# PRELIMINARY DRAINAGE REPORT

## CROSSROADS MIXED USE EL PASO COUNTY, COLORADO

NOVEMBER 2020

PCD Filing No.:  
SP-20-011

File: C:\180031-Crossroads Mixed Use\Drawings\GR02.dwg PlotStamp: 11/23/2020 12:05 PM

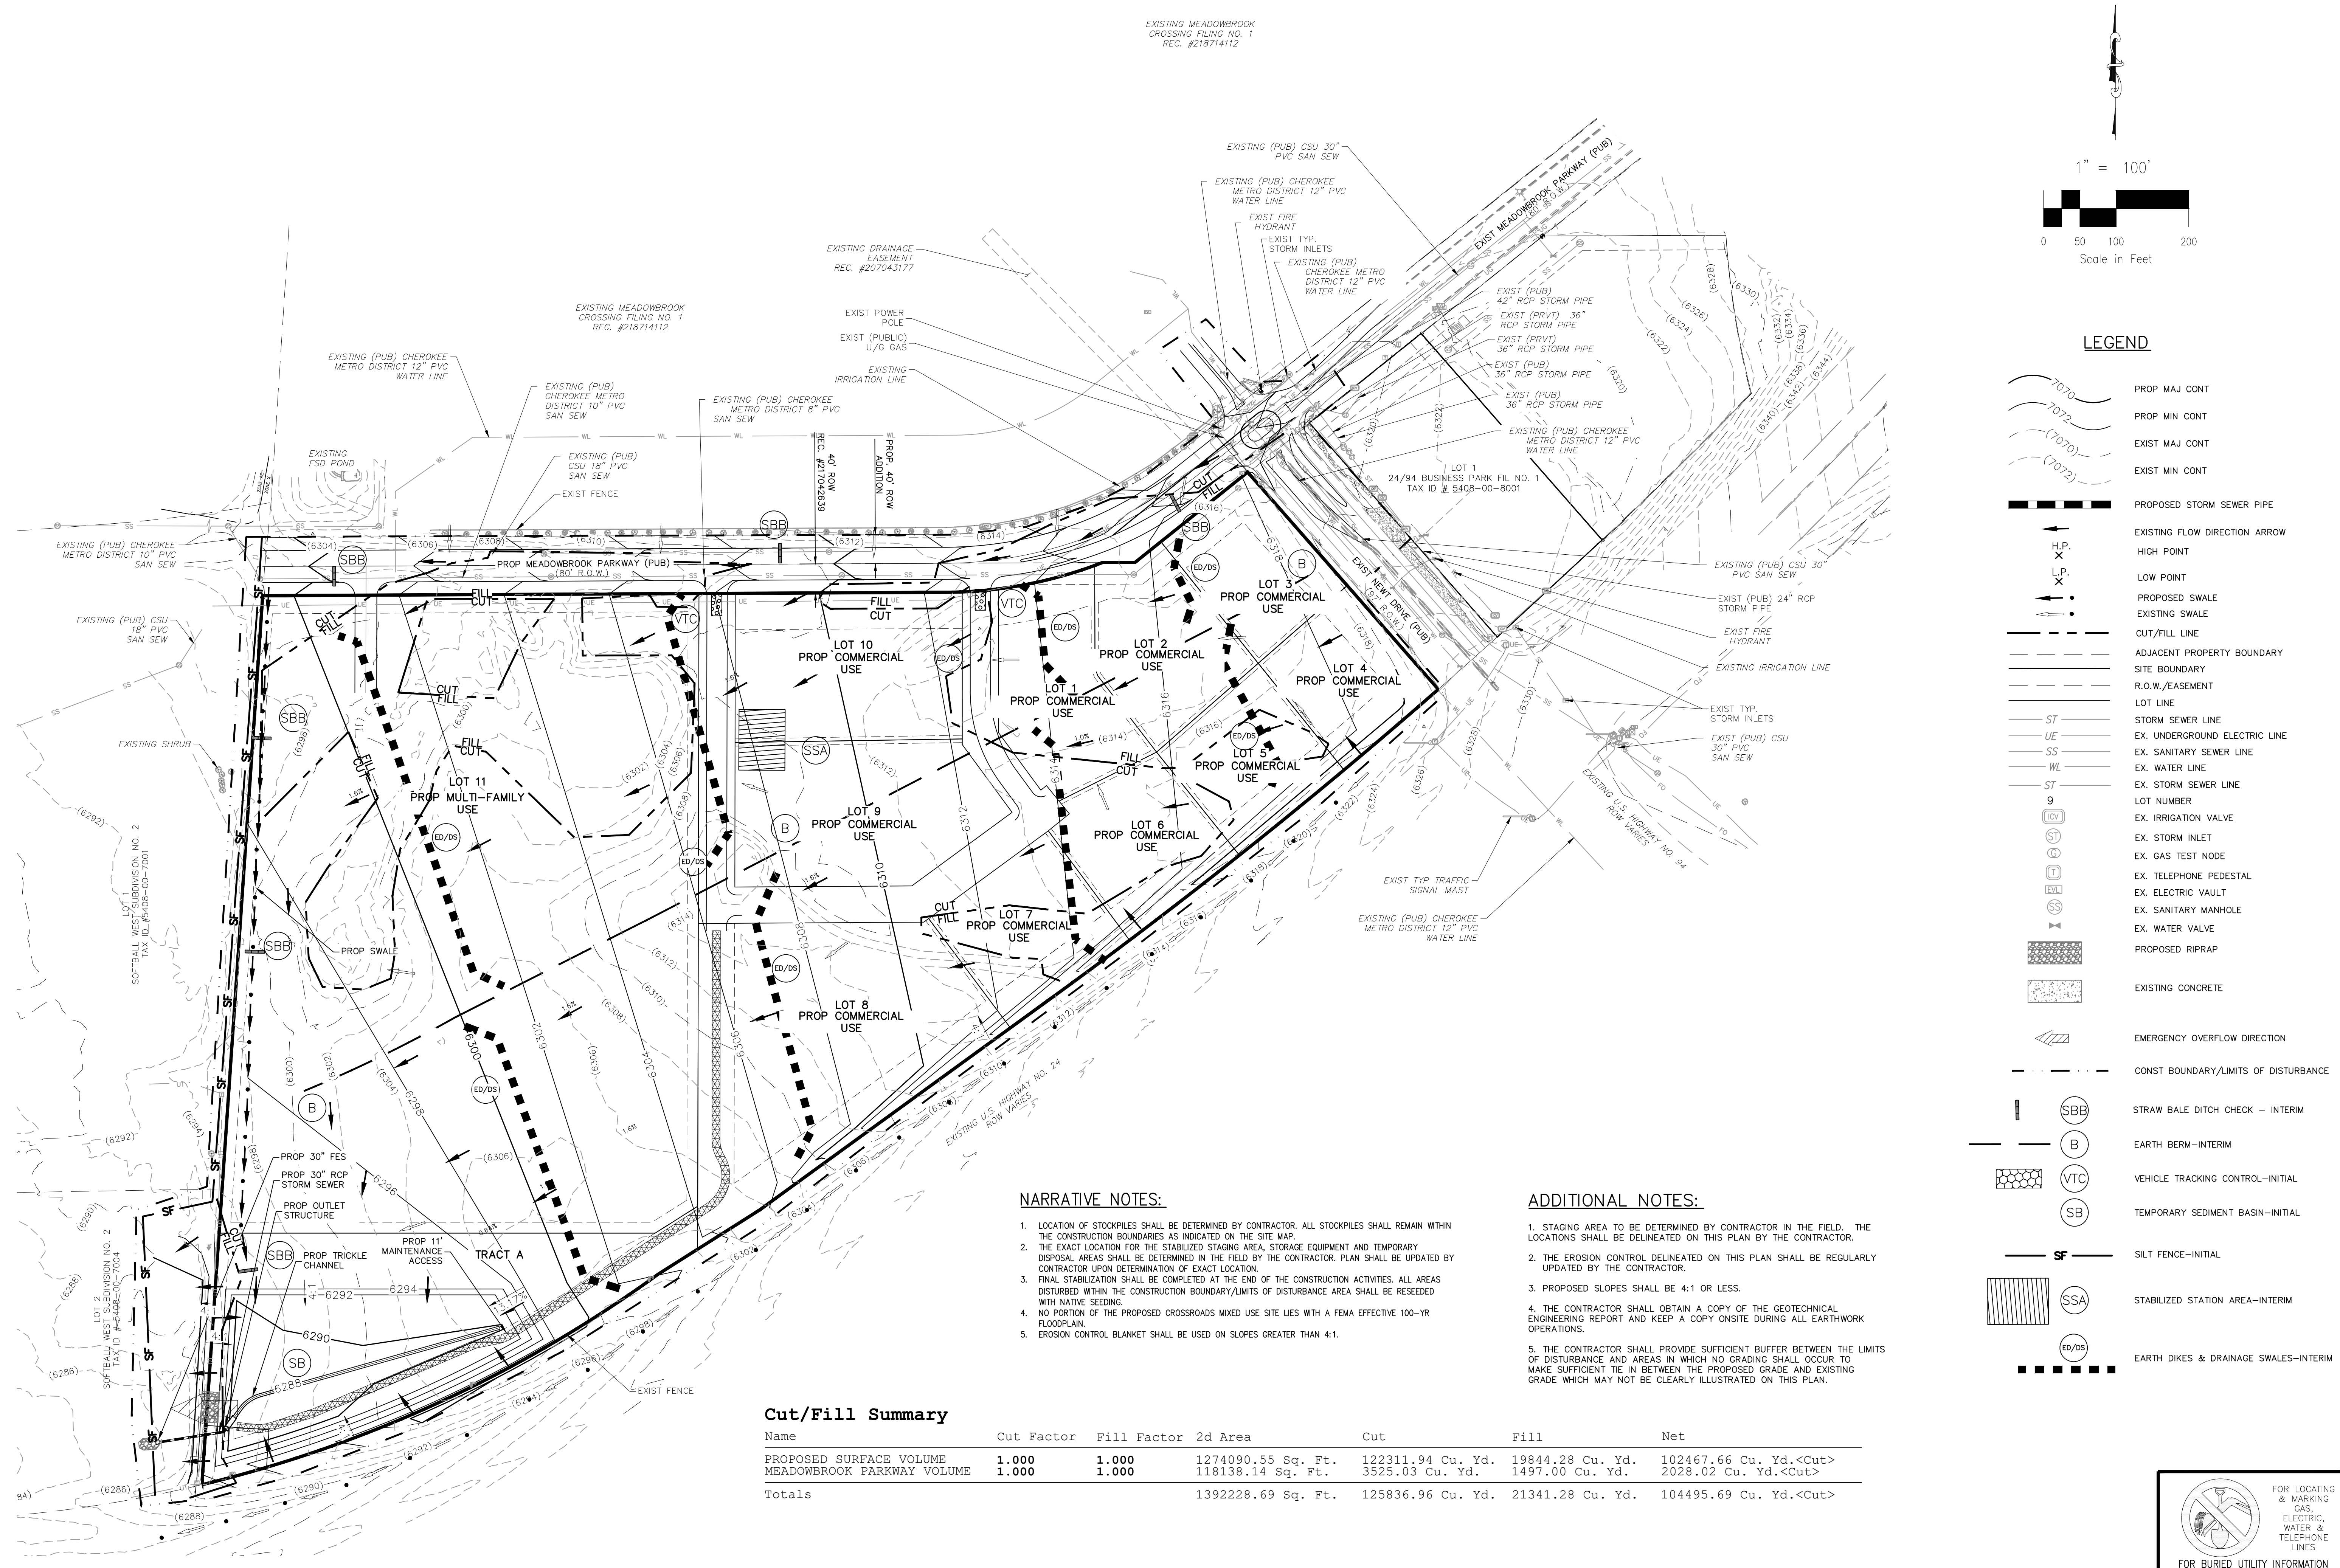
update. Only one  
temporary sediment  
pond is shown on the  
plans.

Only one SB shown on GEC plans. Revise this text accordingly.
